Please ask for: Ms Iqraa Malik
Email: iqraa.malik@terraquest.co.uk
Telephone: 01212341390
Our Ref: LU/297/20/HH
Your Ref:
Date: 30th October 2020

Application for Planning Permission for Works or Extension to a Dwelling

Development: Replacement doors and windows
Location: 9 Redwood Court St Floras Road Littlehampton BN17 6BB

SITE PLAN - 1 : 500

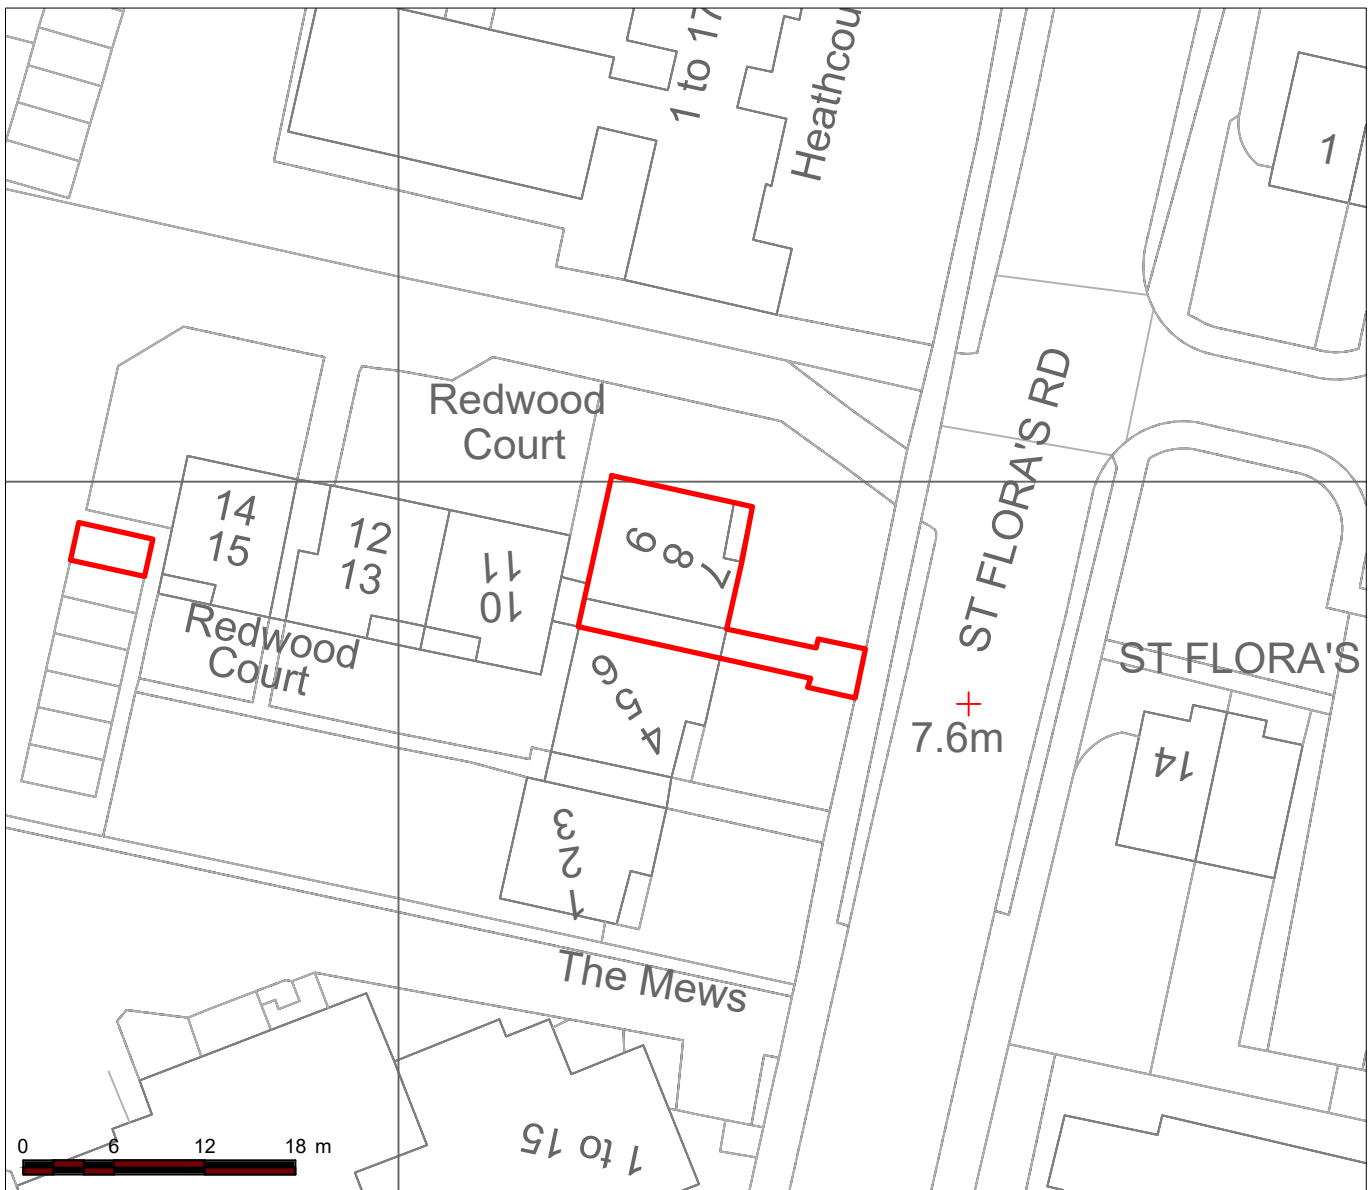
Location Plan

The measurements on the scale bar for the location plan are unclear. Please amend.

Location Plan & Block Plan

The location and block plan submitted has two red outlines. Please amend to show the application site outlined in red and any other land in your ownership in blue.
